Response to Submissions - Table

Mechanical and Manufacturing Engineering Building (J17+ J18)

SSD – 12_5572

UNSW School of Mechanical and Manufacturing Engineering
Proposed Elevations J17
West Elevation

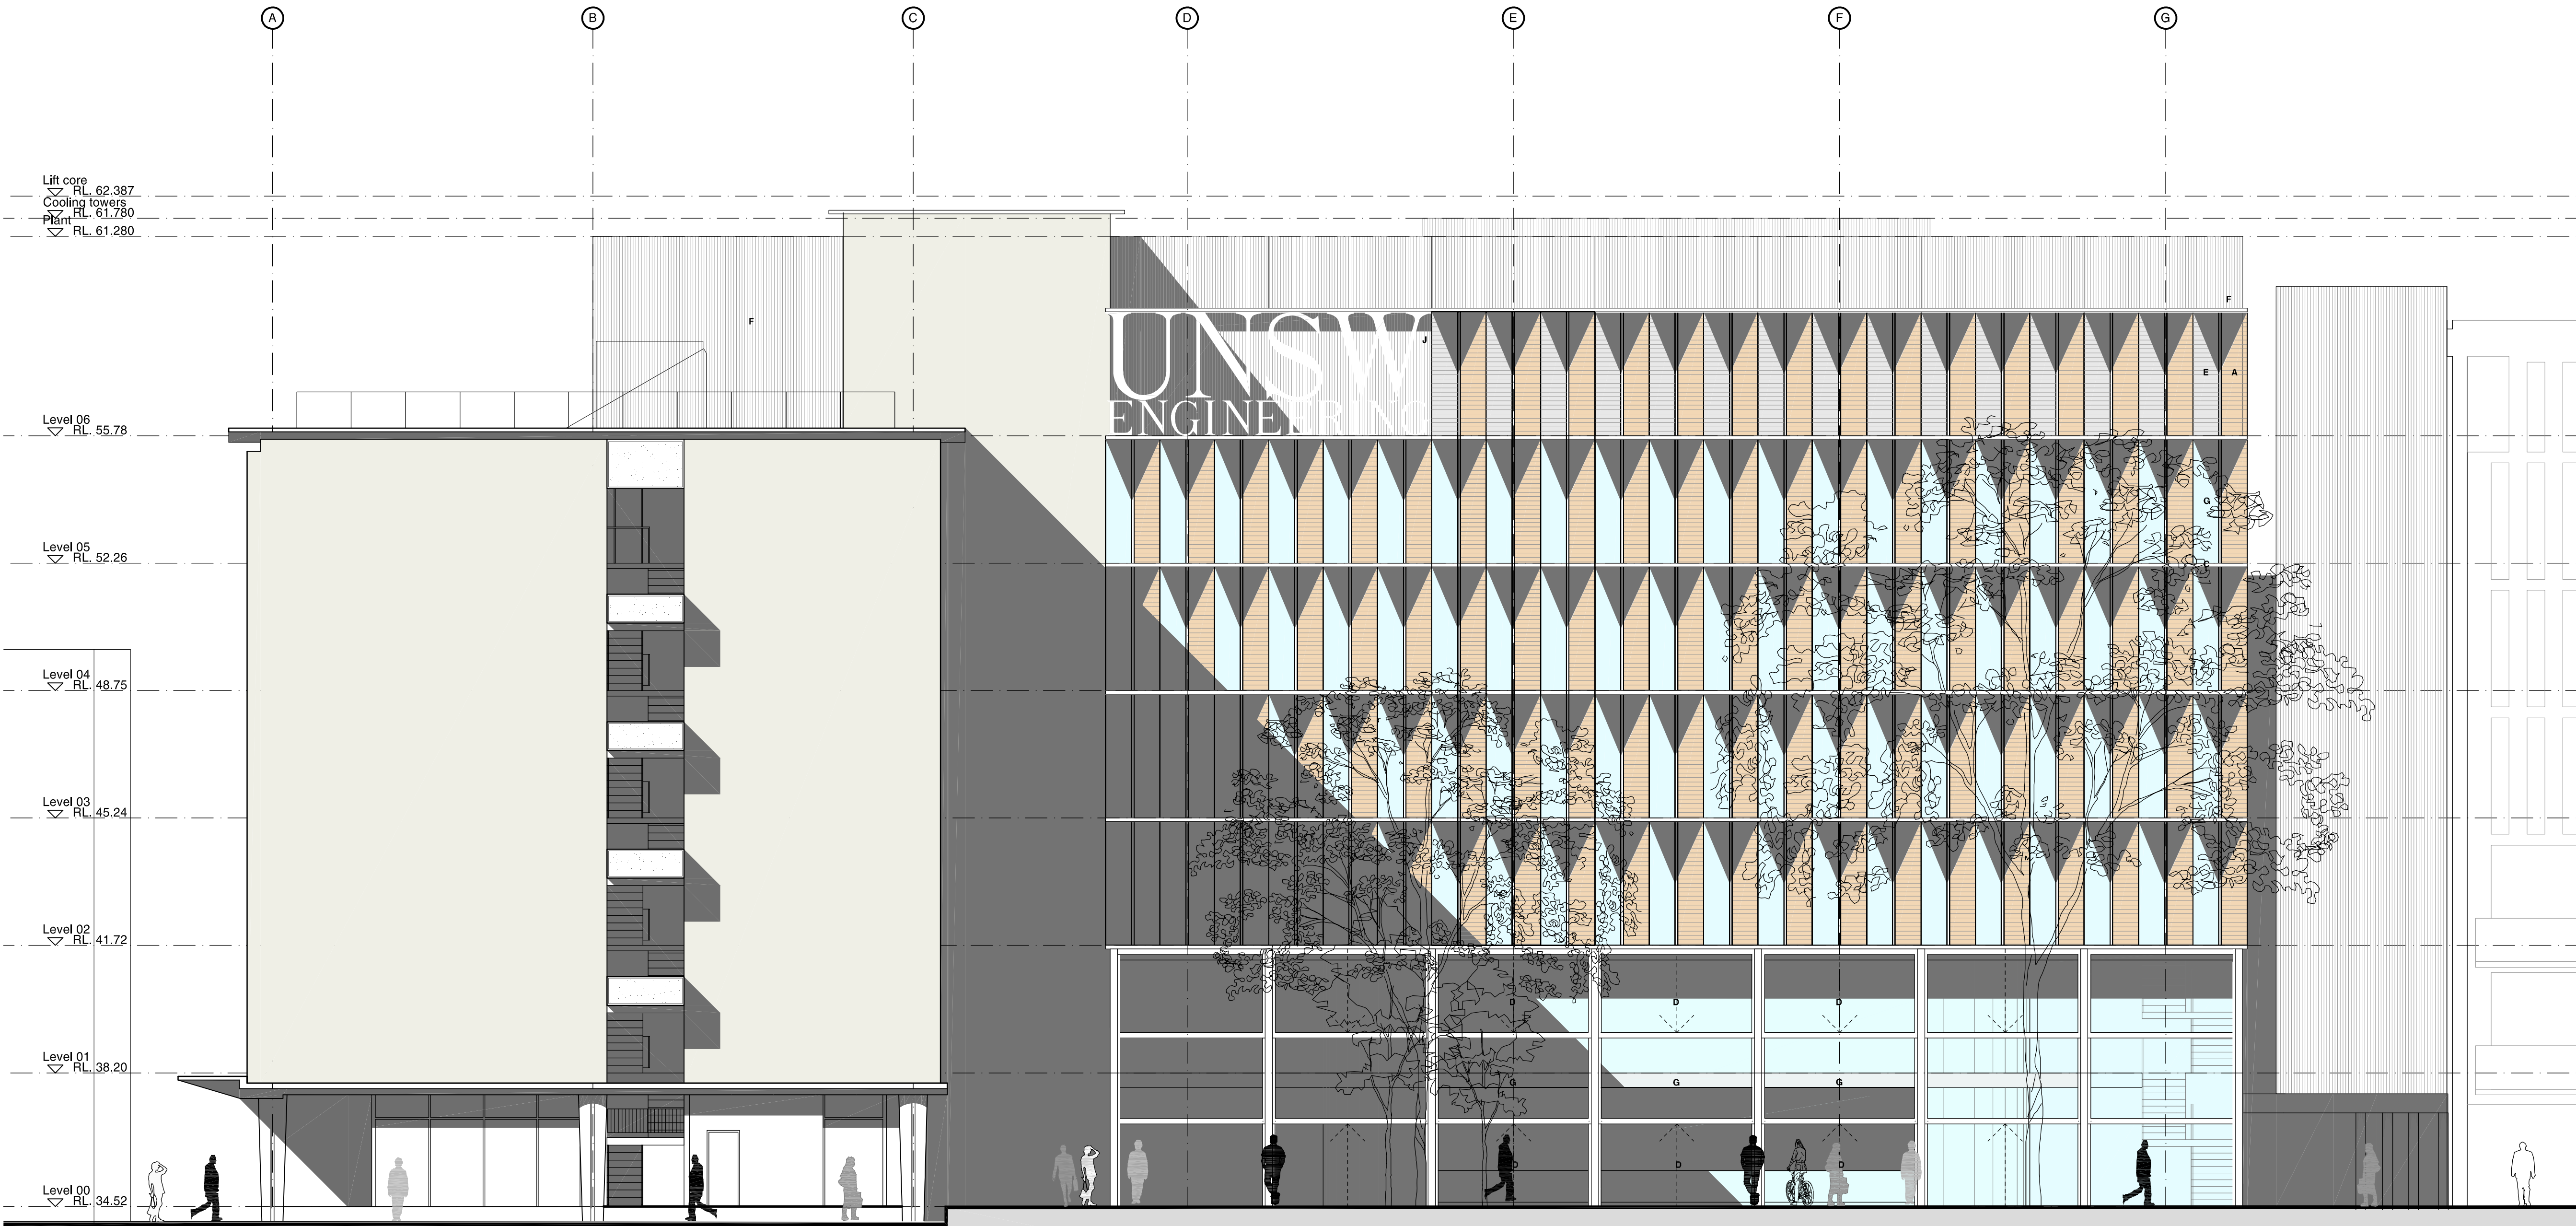
Height	- o Building J17 currently exceeds the maximum building wall height of 18m having a wall height of approximately 21m and proposed height of 27m. - o The proposal including the enclosure of plant exceeds the wall height control by 6m. - o The enclosure of plant appears excessive and contributes to an increase in height, bulk and scale over the extent building. - o Council consider that there are reasonable grounds for a reduction in height of this enclosure - o The proposed height has potential to introduce a loss of view impacts to adjoining properties on Willis Street, and a visually bulky built form precedent.	- o The proposed building height is suitable, given the merits of the application, noting that there is no LEP height control which governs development on this part of the site. - o The Campus DCP identifies a maximum building height of 24m for Building J18. An 18m height limit with a depth of 30m has been identified within the Randwick LEP 2012. Should a development (with a complying envelope) be constructed on Building J18, views from these dwellings would be further diminished. - o The plant room is requirement to house the plant to service the building uses, as well as mitigate acoustic impacts to nearby residents in Willis Street. - o The proposed building height (RL 63.88) is sits marginally above that of the current maximum building height (RL62.22) (lift overrun). - o Following submission of the EIS, the size and height of the plant enclosure was further considered by the architects in consultation with mechanical and structural consultants. - o The design and required sizing of the plant enclosure has been considered extensively, and the dimensions provided are required to house the building plant requirements in a functional, efficient, and orderly manner. - o The height of the building's plant allows for a superior environmental health outcome with regard to any potential Legionella outbreak from the cooling towers. The additional height allows for improved and required separation from the occupants of the building, as well as improved air through-flow over the towers. - o Further, and more importantly, the plant enclosure has also been specifically designed to minimise the acoustic impact to adjoining residents and does not result in any other or new amenity impacts.
